22 April 2020

SSC 7664 Mod 1 – Horsley Drive Business Park – Concept Plan

The following letters sets out Council's comments in relation to SSD 7664 Mod 1 for the stage 2 concept design regarding the Horsley Drive Business Park, which is currently on public exhibition. The Modification application is in relation to the construction of Horsley Drive Business Park and includes:

Figure 1 Proposed Plan of Subdivision

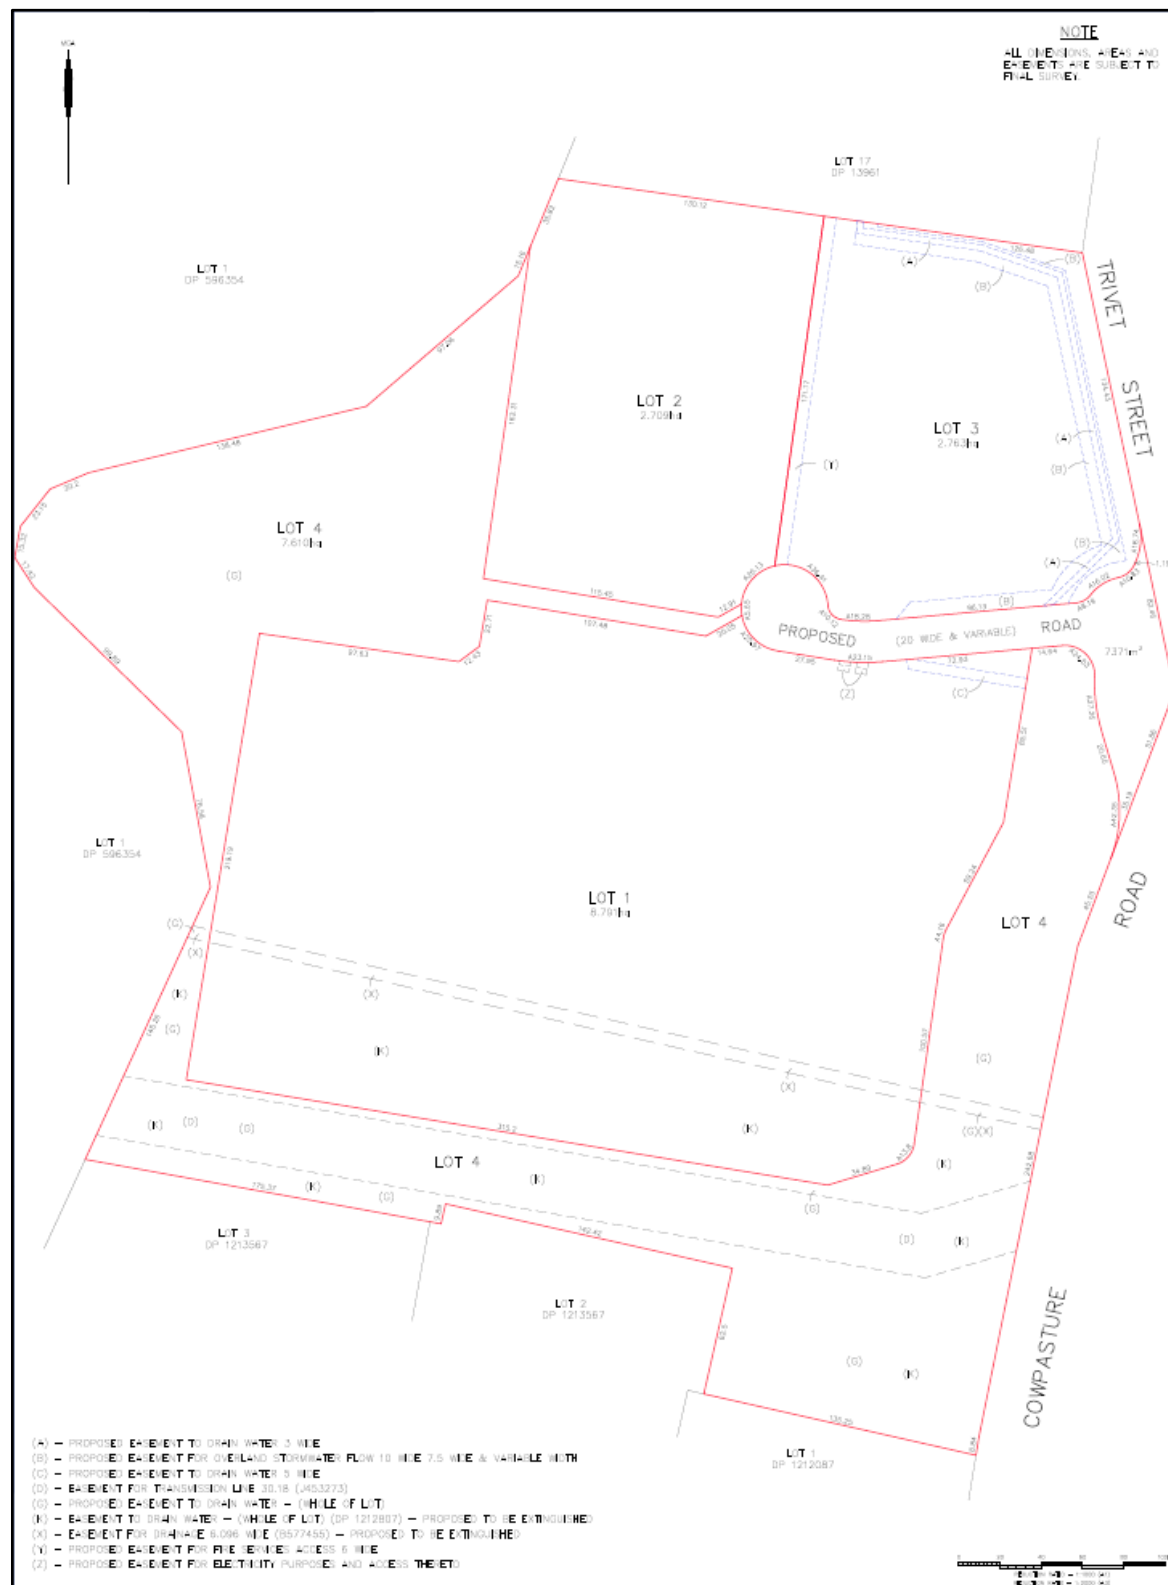
The conditions of consent for SSD 7664 required a landscape setback of 10-metres to Cowpasture Road and a 7.5-metre landscape setback to the proposed access road. In addition to this, the consent required a planter bed for every 10-car parking spaces and retaining walls over 3 metres to be stepped.

The new concept plan for SSD 7664 Mod 1 shows a landscape setback greater than 10 metres to Cowpasture Road. The landscape setback to the northern edge of the new internal road includes a 10-metre wide overland flow path and drainage easement with landscaping plantings; this also acts as a suitable landscaping setback to the northern side of the new internal road.

The southern portion of the new access road includes a 5-metre wide overland flow path and easement that will be fully landscaped. This acts as a landscaping setback to the southern industrial lots. This is non-compliant with conditions of consent for SSD 7664.

It is unclear how many planter beds have been provided in the amended design, however a condition requiring 1 planter box per 10 car parking spaces still applies to the development. As the amended design increases, the number of on-site car parking spaces to 672 there will be 67 planter boxes required onsite.
